Holme Valley Parish Council

Planning applications lodged with Kirklees from 21 01 2020 to 03 02 2020 - List 1920/11. The following applications will be considered by Holme Valley Parish Council at the meeting on 10 02 2020. Where appropriate, recommendations will be made to Kirklees Planning Services regarding whether or not they should be approved, but the decisions will be taken by Kirklees Planning Services. Full details regarding deadline dates for comments and how to submit a comment can be obtained from the Kirklees' website: www.kirklees.gov.uk/planning

Client	Mr Andy Stoddart	Issued From	
Project	1992 : Spring Bank House : Garage	Date	January 20
Title	Existing and Proposed Site Plans	Scale	1:100 @ A1
Drawn	BH	Auth	BH

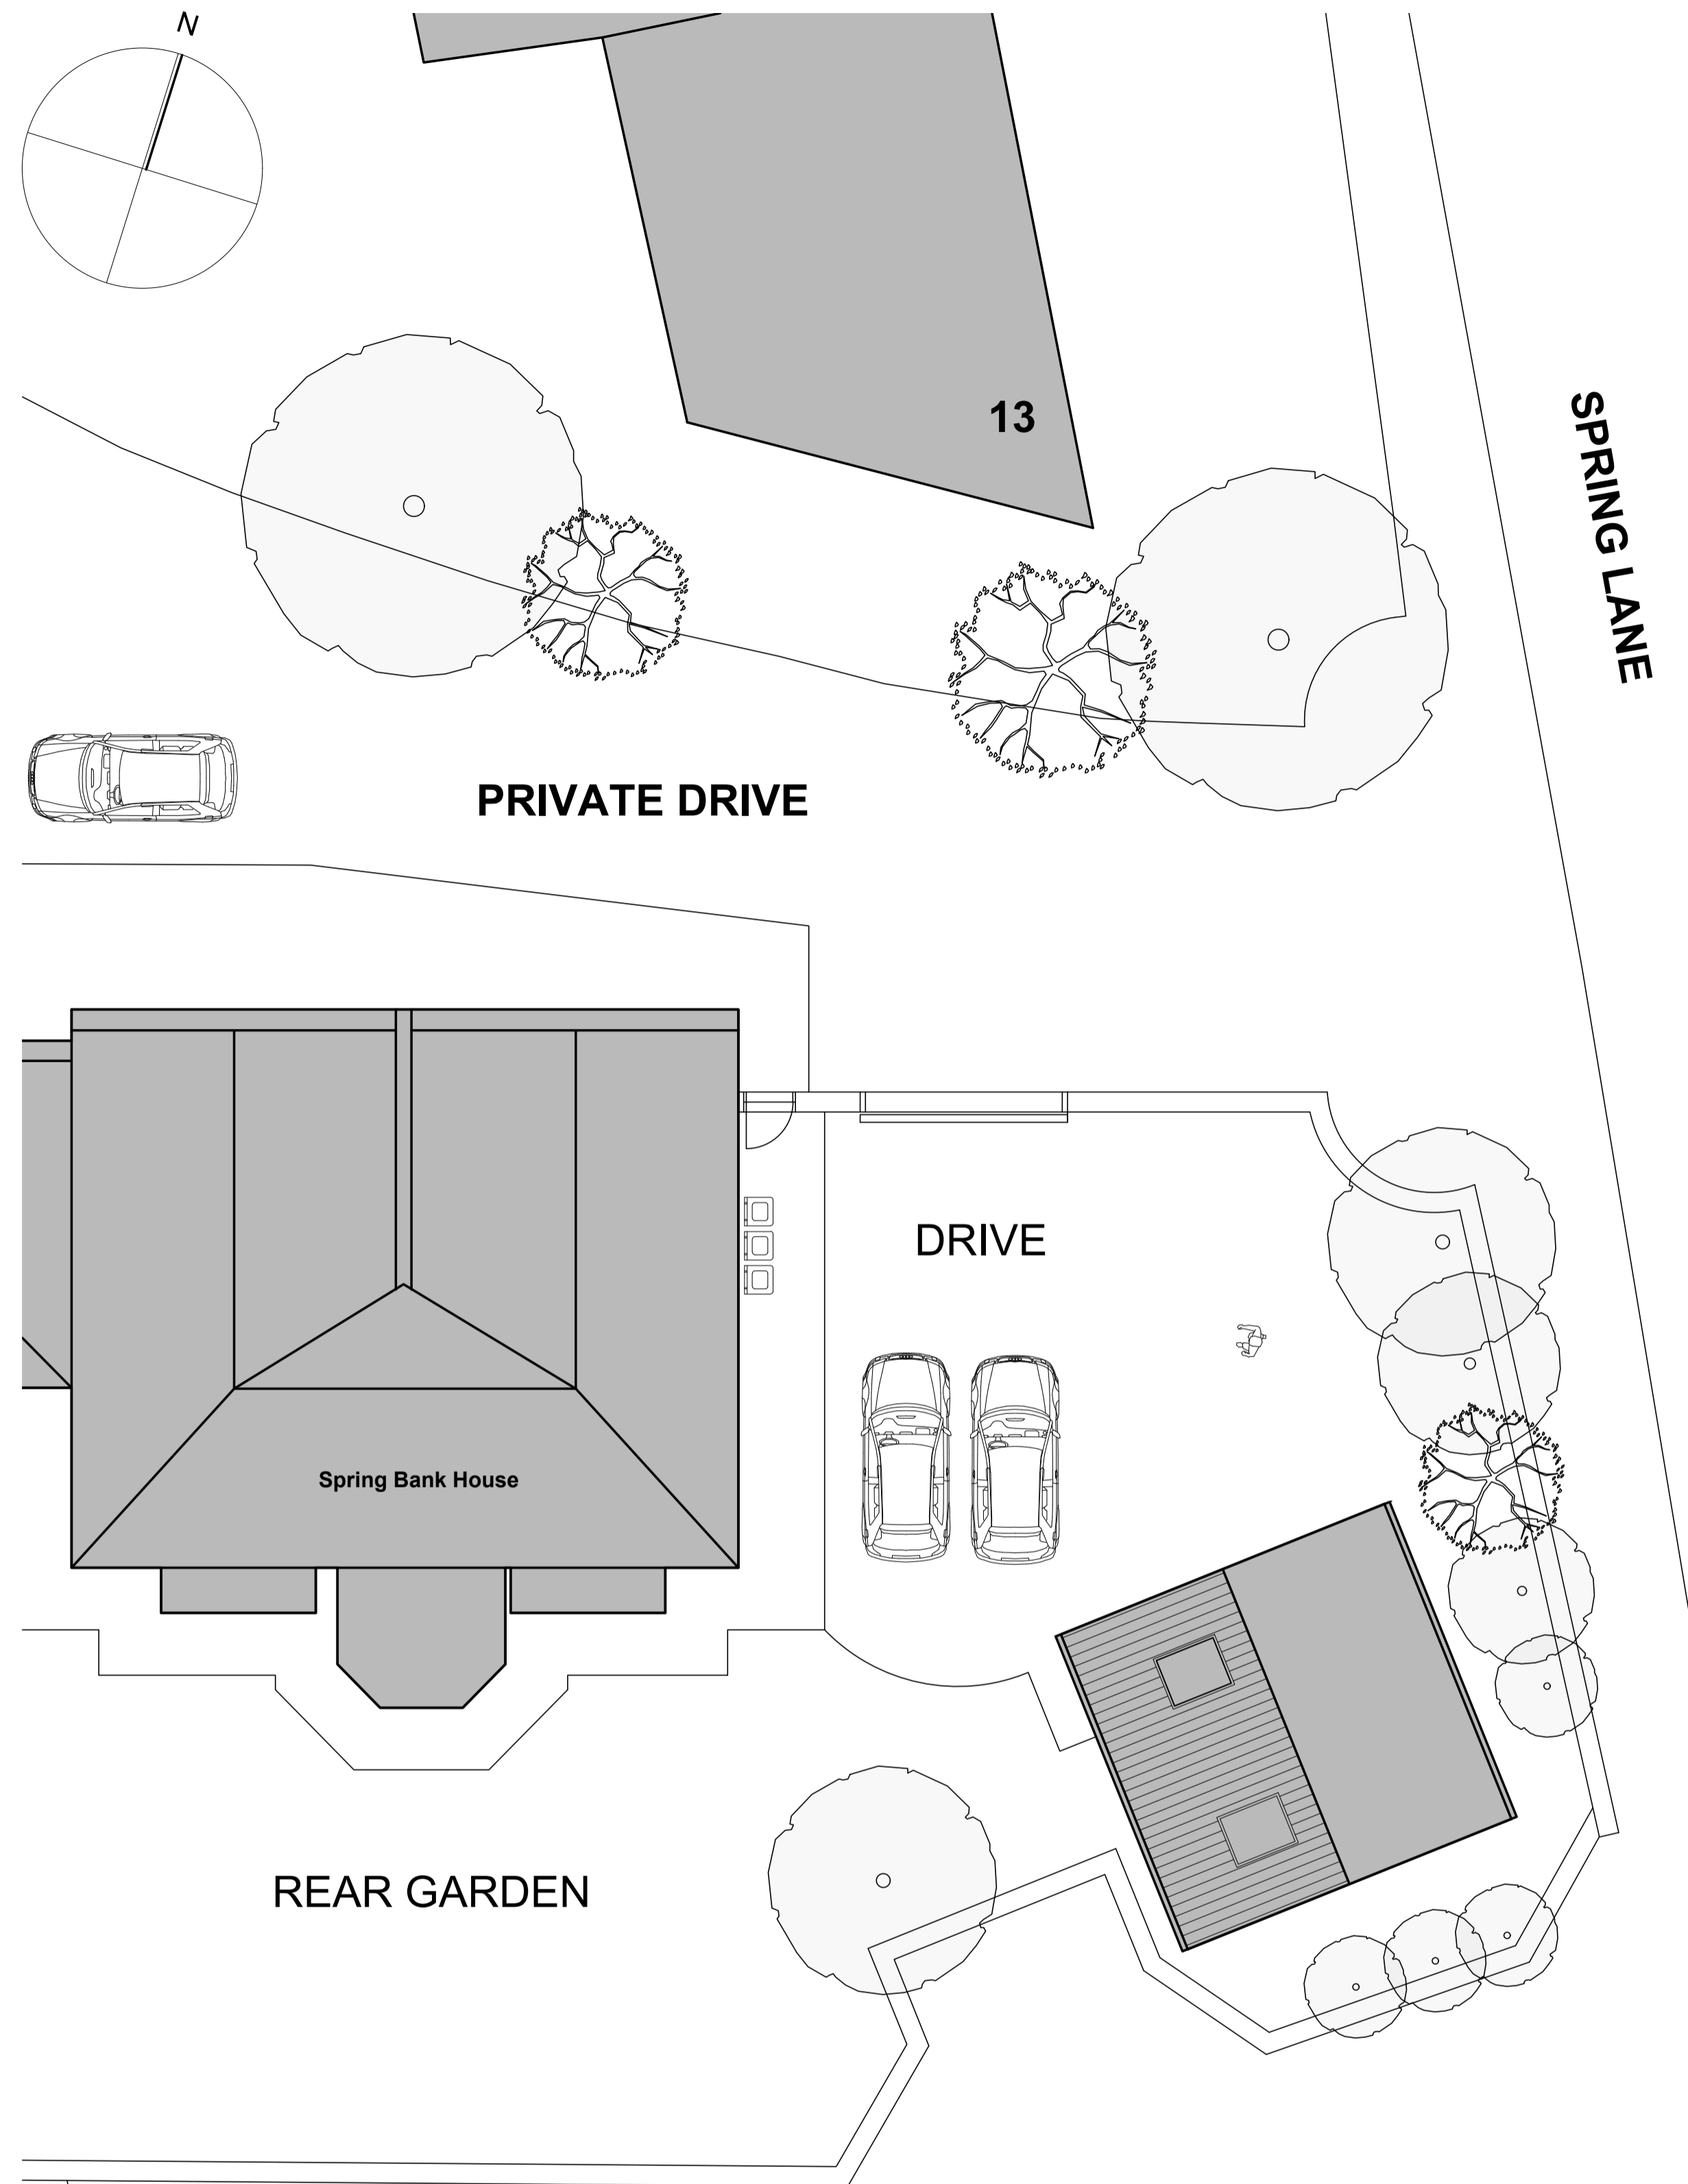
HVPC Reference:	1920/11/04
Application No:	2020/62/90183/W
Location:	Spring Bank House, Spring Bank, Holmfirth, HD9 2LL
Ward/Councillors:	Upperthong – BF/DC
Proposed Development:	Erection of detached garage
OS Map Ref:	SE 413053407867
HVPC Comment:	The Parish Council supports the application but would prefer that the garage be constructed of stone in keeping with the house
Decision:
